# **OXFORDSHIRE COUNTY COUNCIL'S RESPONSE TO CONSULTATION ON THE FOLLOWING DEVELOPMENT PROPOSAL**

**Application no:** 14/02156/OUT-2

**Proposal:** OUTLINE - 95 No new homes

**Location:** Land South Of Cotefield Business Park Oxford Road Bodicote

Figure 17: Illustrative masterplan

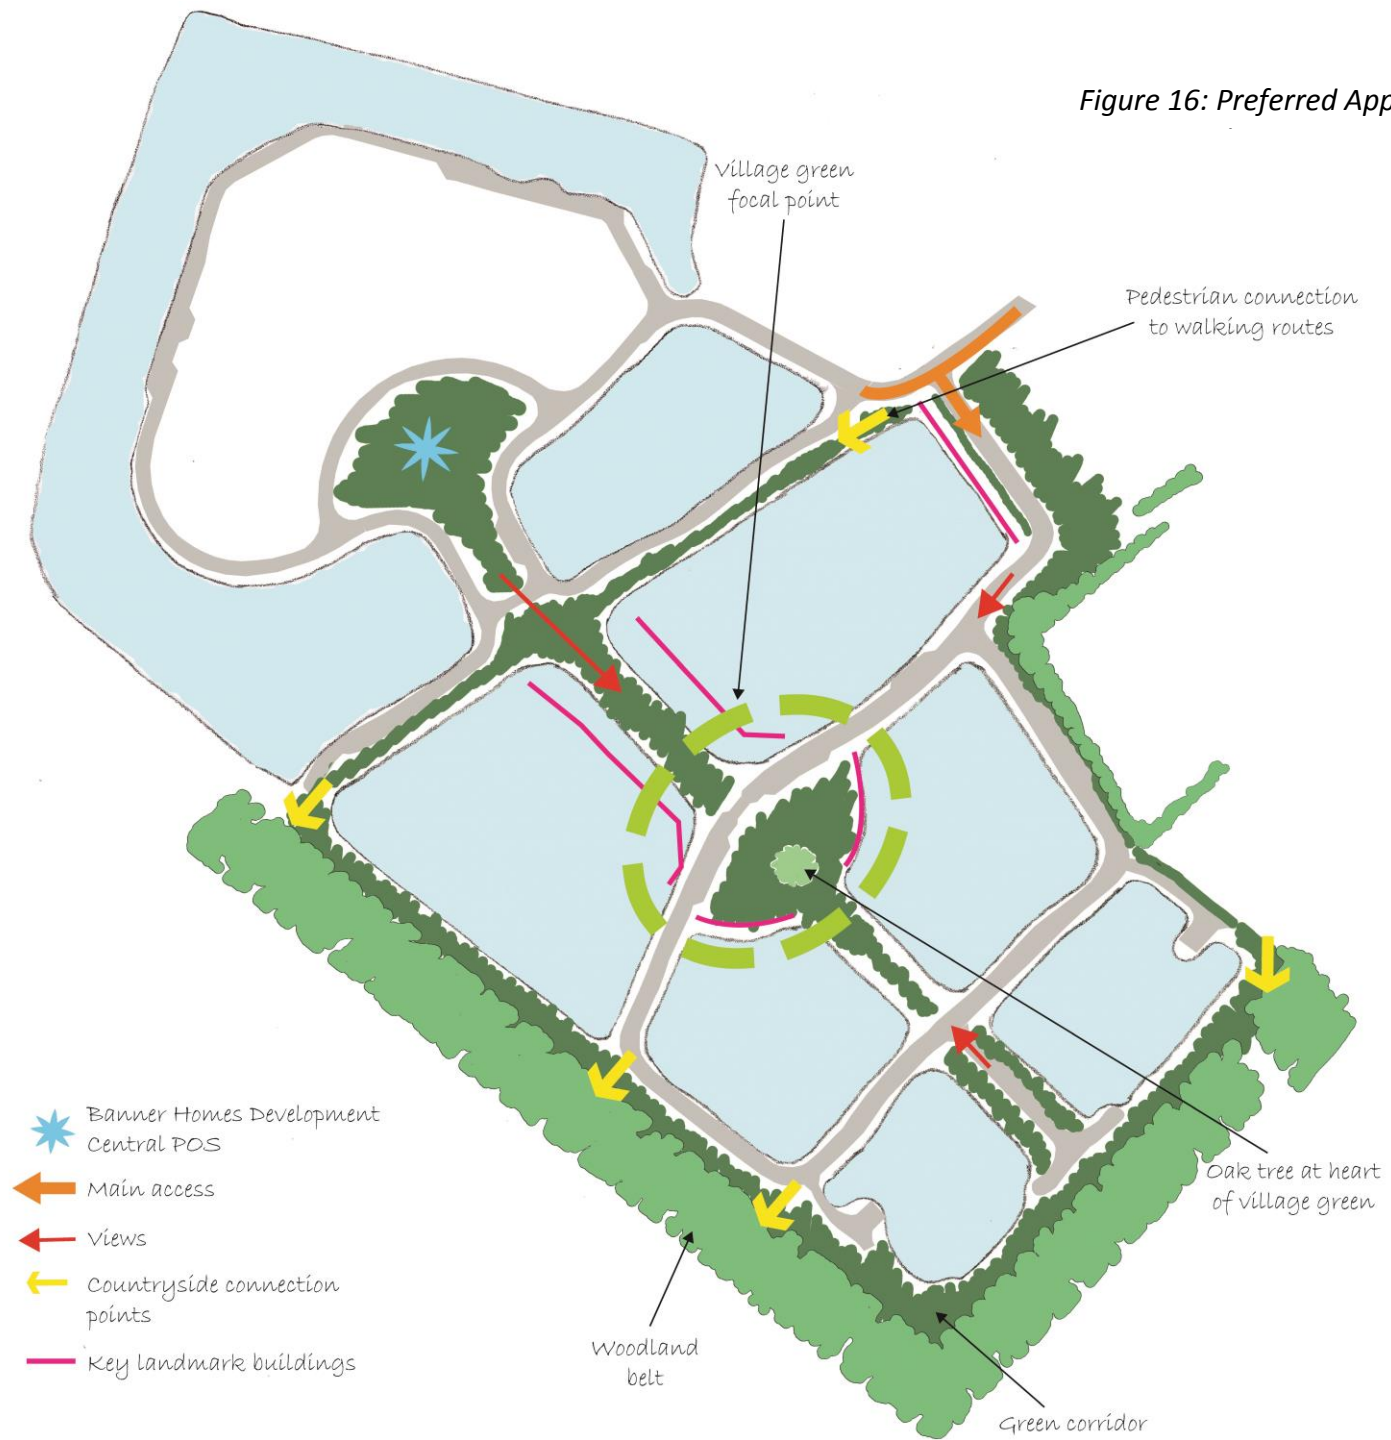
**Indicative masterplan**

This has not been reviewed in detail, so this should not be considered as an exhaustive list of comments:

- I am concerned that the pedestrian/cycle route through the centre of the development should be suitable for shared use in all weathers and should be as direct as possible.
- Footpath connections need to be provided into the surrounding footpath/PRoW network.
- Tracking for the full route of a large refuse vehicle will be required with a reserved matters planning application. For areas where manoeuvring into parking spaces looks tight, tracking for a large family car will also be required.

Figure 22: Potential Footpath Network Improvements

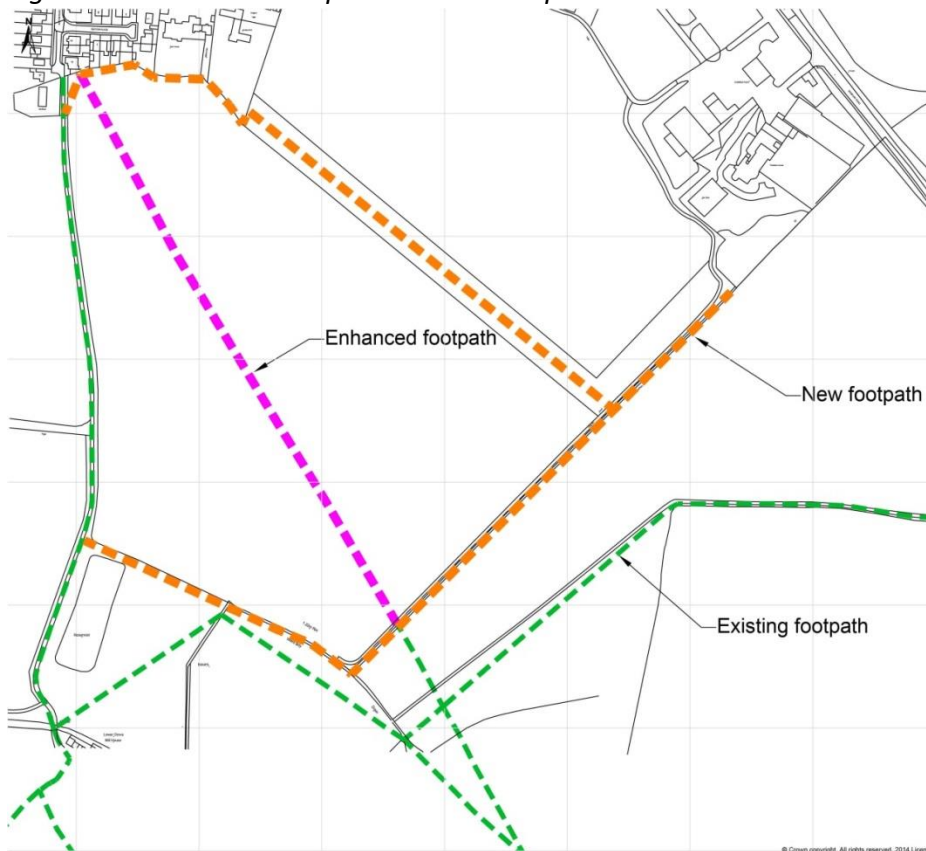
Requirement to ensure the proposed new walking routes are provided and maintained in perpetuity.

<p>Development shall not begin until details of pedestrian links from the site to the western side of Oxford Road and to Molyneux Drive. have been submitted to and approved in writing by the Local Planning Authority, and no building shall be occupied until those links have been constructed in accordance with the approved details.</p> <p>REASON: to ensure that the site is conveniently accessible by sustainable means.</p>
